GRADING AND EROSION CONTROL PLAN

JUDGE ORR ROAD RV PARK AND STORAGE

EL PASO COUNTY, COLORADO

FIGURE OS-5 TYPICAL OUTLET STRUCTURE WITH WELL SCREEN TRASH RACK

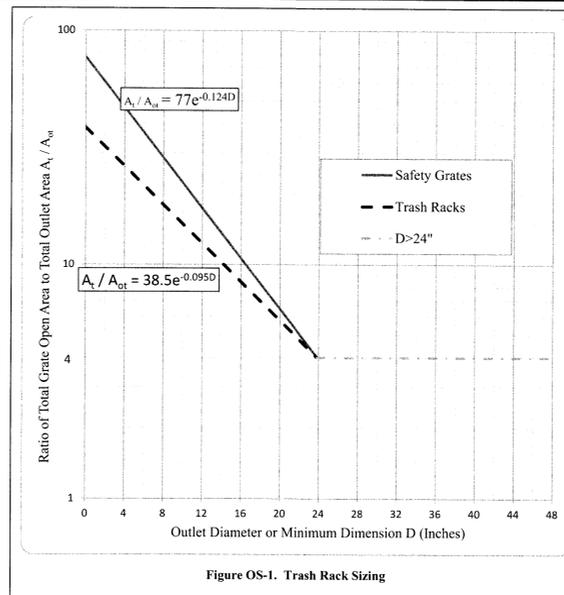
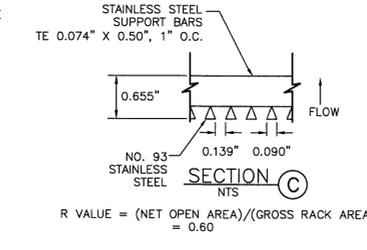
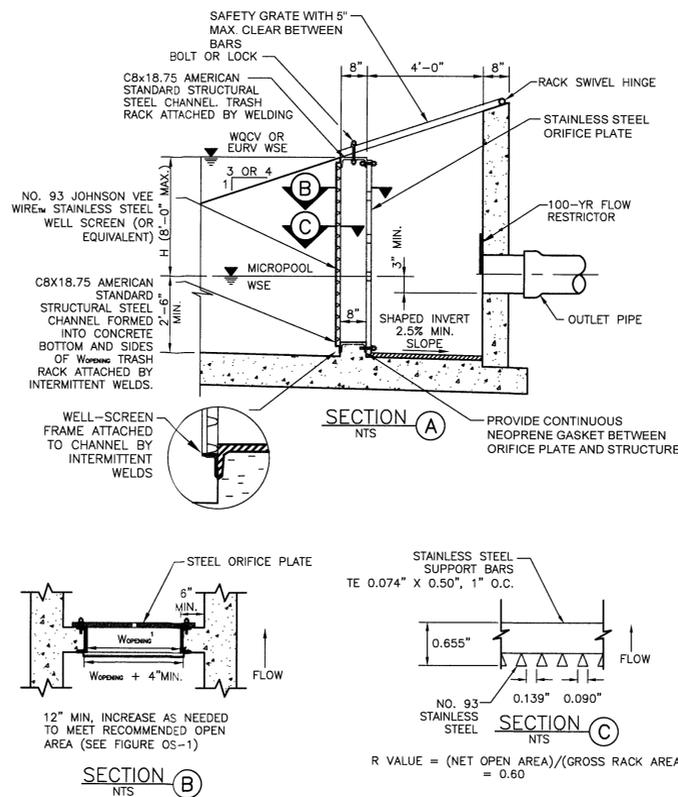
Revise. Depth of pipe invert does not match the drainage report.

Revise. Height above the invert does not match the drainage report.

SEDIMENT BASIN PLAN

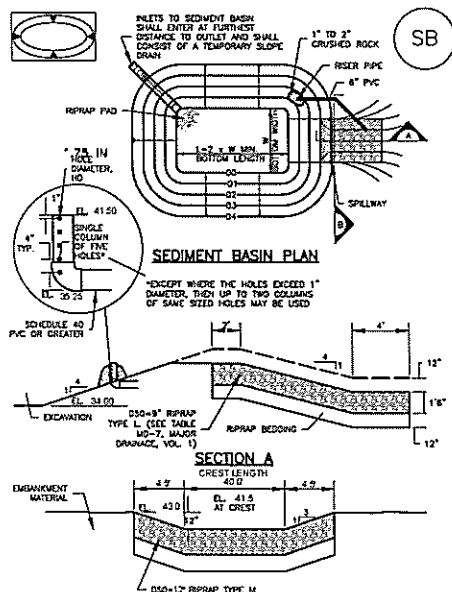
Identify the specific construction requirements for the riser pipe (hole diameter and riser pipe height, diameter, etc) and not rely on the general contractor to interpret Table SB-1 correctly. Table SB-1 is for standard basins which does not seem to apply to the pond configuration shown on the grading plan.
